**Date:** 12 August 2025

**PLANNING APPLICATION CONSULTATION RESPONSE**

<b>Application Number:</b>	3/2025/0141
<b>Proposal:</b>	Regularisation of erection of three commercial buildings (10 commercial units Use Class E) and associated works.
<b>Location:</b>	Bolton Fold Farm Alston Lane Longridge PR3 3BN

**Drawing Title**  
 PROPOSED SITE PLAN

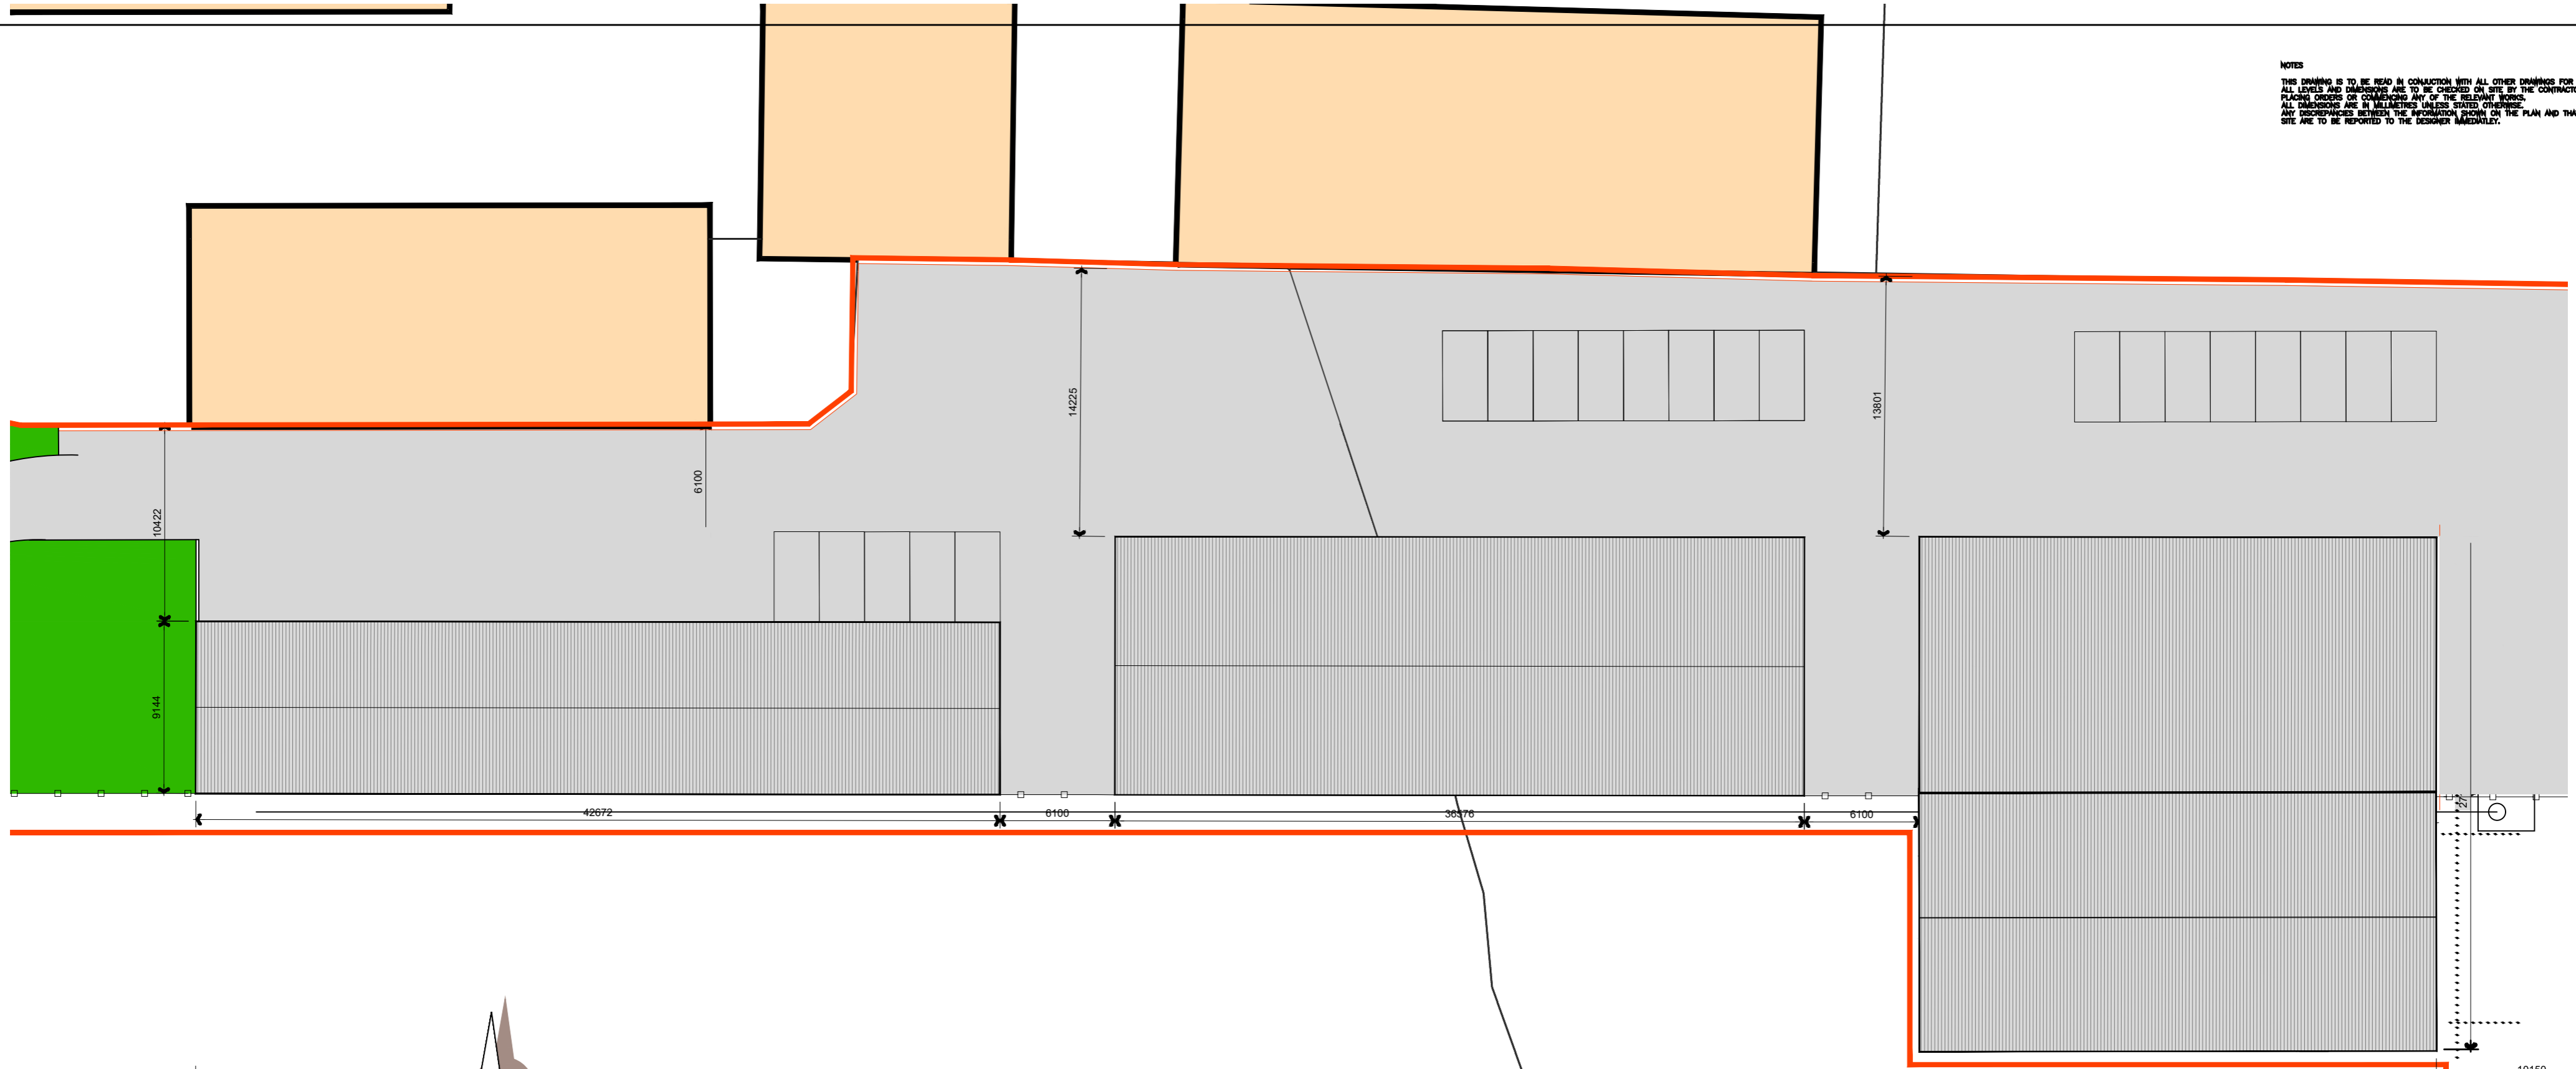
Whilst it is acknowledged that some details pertaining to a final detailed surface water sustainable drainage strategy have been provided by the applicant, the evidence provided is currently incomplete, therefore further details will still need to be secured from the applicant in order to ensure that surface water will be safely managed over the full lifetime of the development, without resulting in any increased risk of flooding, either on or off site.

- i. Site plan showing all permeable and impermeable areas that contribute to the drainage network either directly or indirectly, including surface water flows from outside the curtilage as necessary;

- ii. Final detailed sustainable drainage system layout showing all pipe and structure references, dimensions and design levels;
  - iii. Details of all sustainable drainage components, including landscape drawings showing topography and slope gradient as appropriate;

- iv. Drainage plan showing flood water exceedance routes in accordance with Defra Technical Standards for Sustainable Drainage Systems;
  - v. Details of proposals to collect and mitigate surface water runoff from the development boundary;

The proposed drainage system has been designed using default parameters in MicroDrainage. This may result in the system being undersized. The applicant must provide robust justification for all parameters used. Specifically;

- a) Runoff coefficients – Default values of 0.75 / 0.84 have been applied. In line with the [Lancashire SuDS Pro-forma](#) and [accompanying guidance](#), the applicant is expected to apply a runoff coefficient of 1 when modelling impermeable areas.
- b) Maximum Rainfall – The value of 75 mm/hr has been applied. This parameter should be set to the maximum possible value as it can cap the maximum rainfall intensity able to enter a system so if a modelled storm has an intensity higher than the input value then all water above this is lost.

- c) MADD Factor – A factor of 2.0 (20 m<sup>3</sup>/ha) has been applied. The default value of 2 assumes that 20m<sup>3</sup> of water is lost between hitting the ground and reaching the drainage network from things such as localised depressions and cracks in paved surfaces. For new developments these should not exist so to avoid underestimating volumes entering the drainage network this value should be set to 0.
